**To:** Charlotte Planning, Design & Development

**Date of Review:** September 27, 2021 (***Revised November 22, 2021***)

**Rezoning Petition #:** 21-130

**Recommendations  
Concerning Storm Water (11/22/21):**

RZ1.0

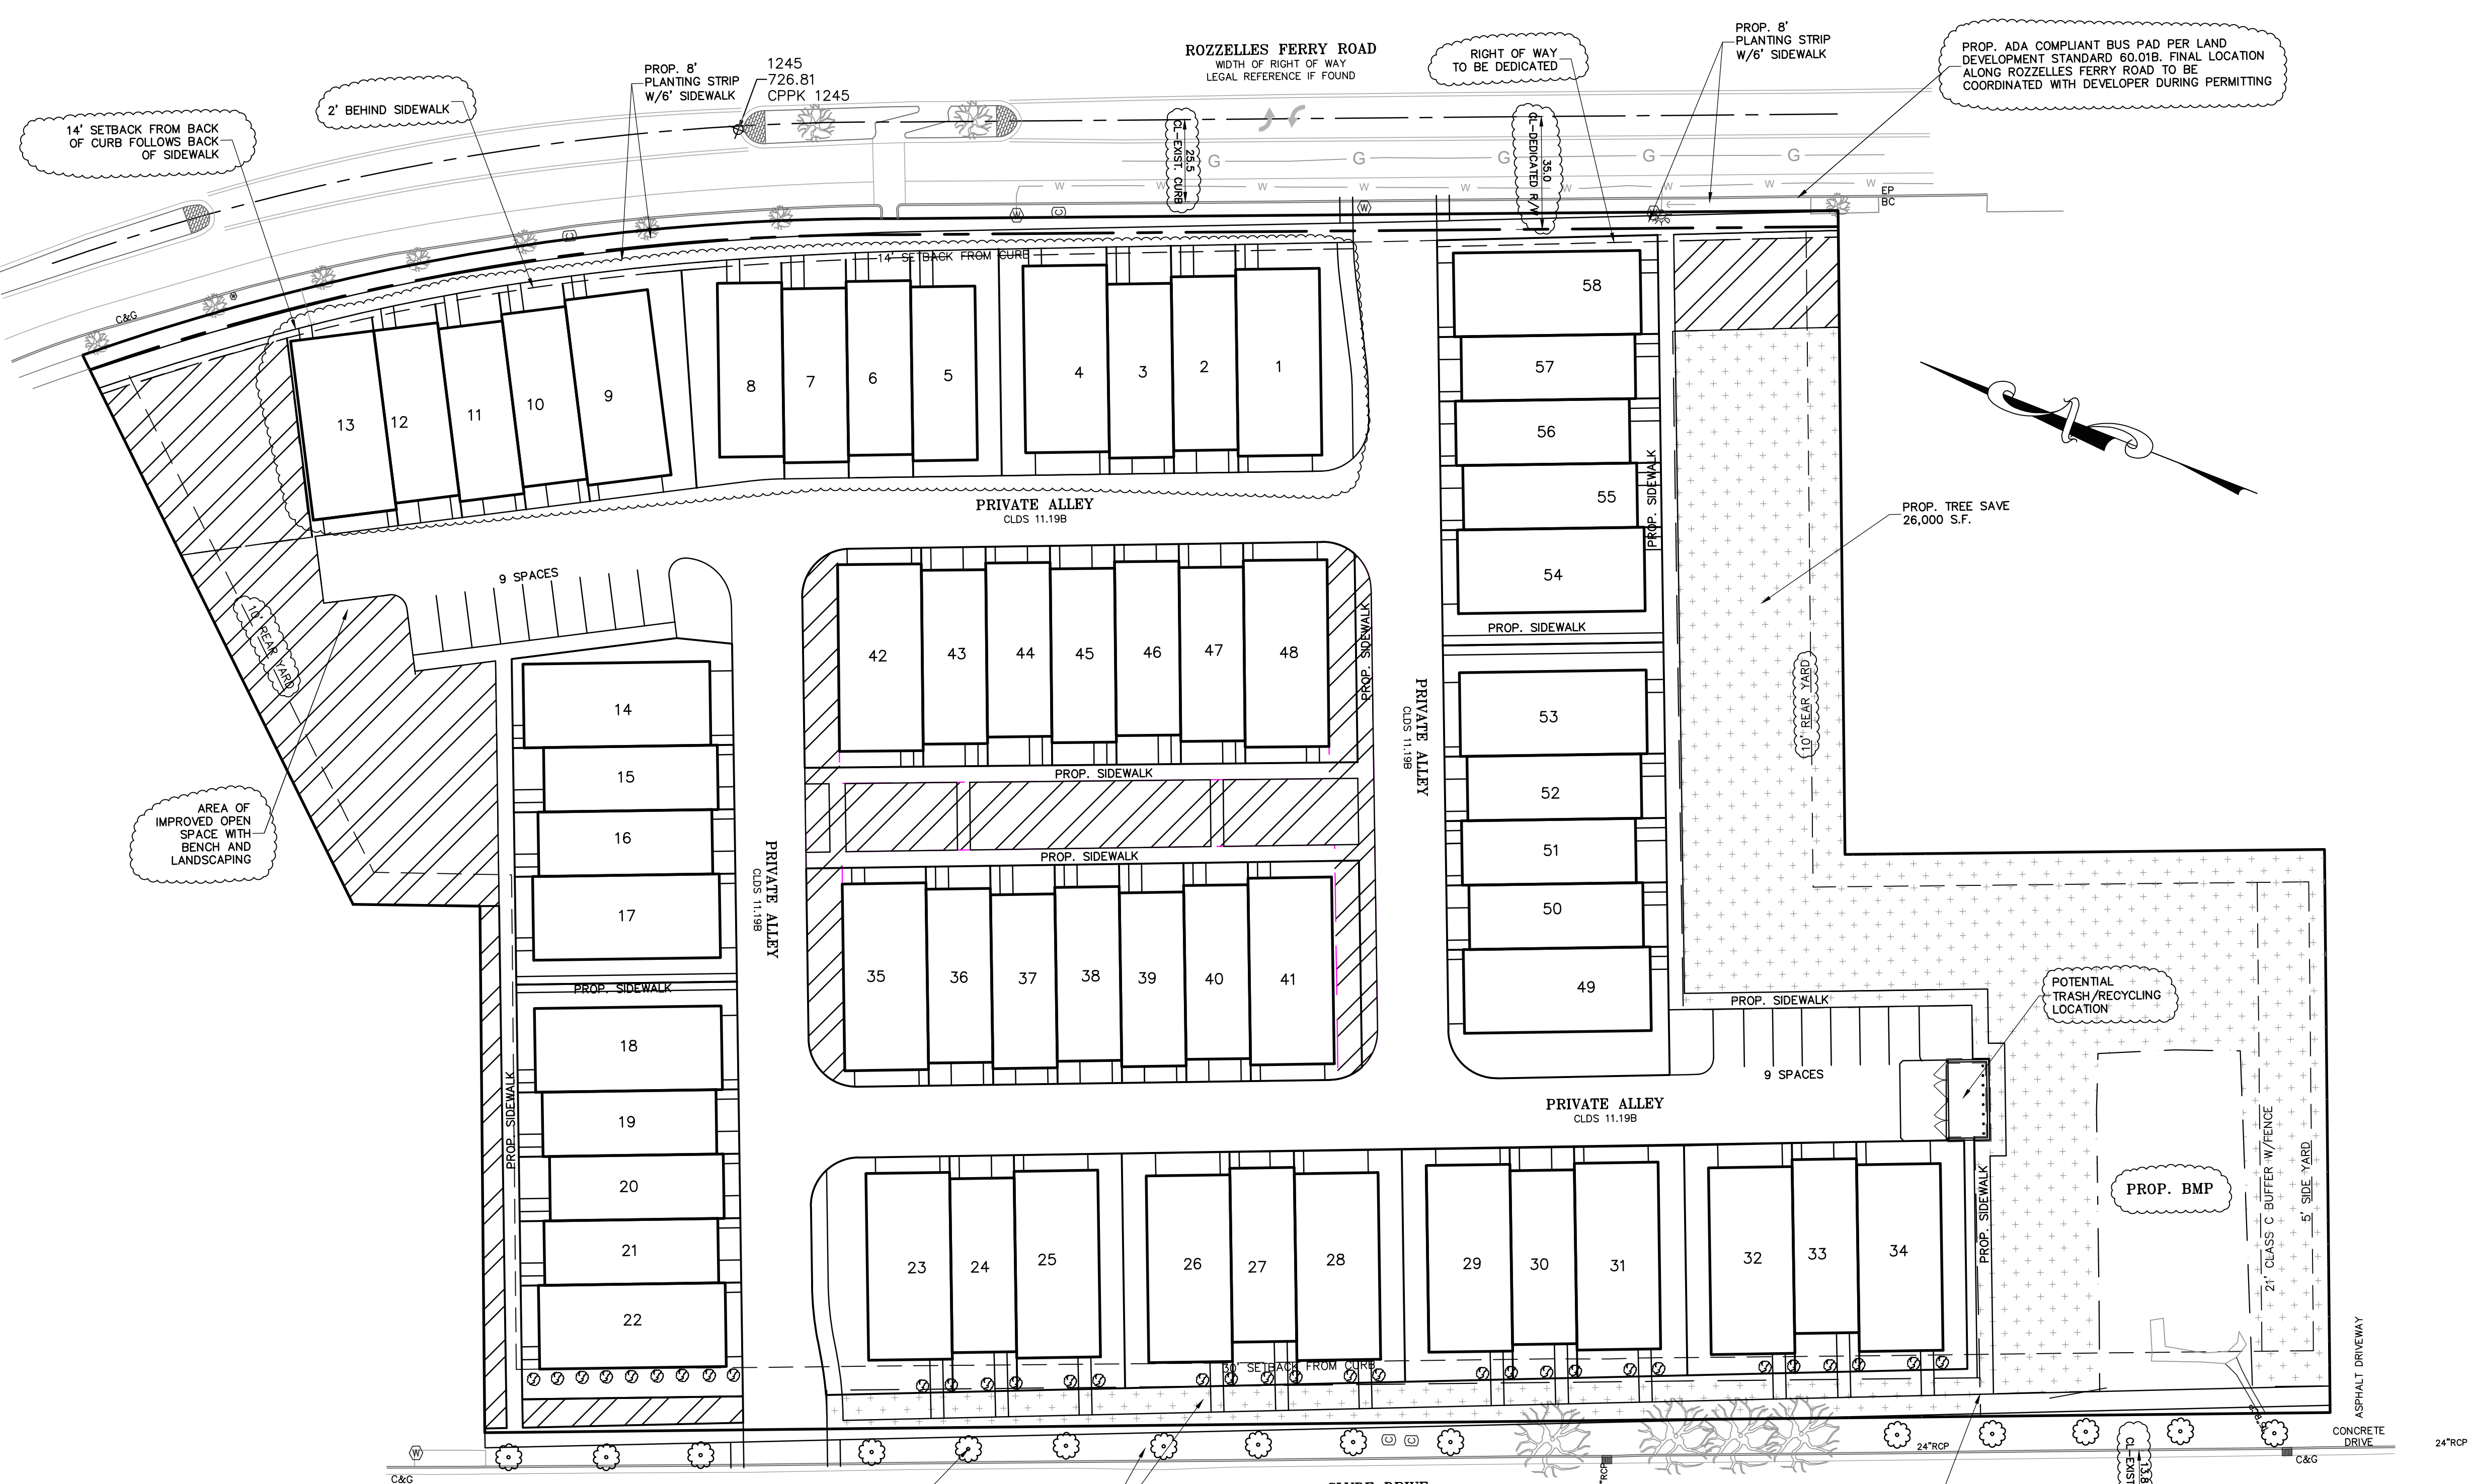
**This property drains to the Irwin Creek, which is an impaired/degraded stream, and may contribute to downstream flooding. This project has the opportunity to mitigate future impacts to this stream, therefore, Storm Water recommends placing the following notes on the plan:**

For defined watersheds greater than 24% built-upon area (BUA), construct water quality stormwater control measures (SCMs) designed for the runoff generated from the first 1-inch of rainfall for all new and redeveloped BUA associated with the project. SCMs must be designed and constructed in accordance with the Charlotte-Mecklenburg BMP Design Manual.

For defined watersheds greater than 24% built-upon area, control the entire volume for the 1-year, 24-hour storm for all new and redeveloped BUA associated with the project. Runoff volume drawdown time shall be in accordance with the Charlotte-Mecklenburg BMP Design Manual.

For commercial projects with greater than 24% BUA, control the peak to not exceed the predevelopment runoff rates for the 10-yr, 6-hr storm and perform a downstream flood analysis to determine whether additional peak control is needed and if so, for what level of storm frequency, or if a downstream analysis is not performed, control the peak for the 10-yr and 25-yr, 6-hour storms.

For residential projects with greater than 24% BUA, control the peak to not exceed the predevelopment runoff rates for the 10-year and 25-year, 6-hour storms or perform a downstream analysis to determine whether peak control is needed, and if so, for what level of storm frequency.
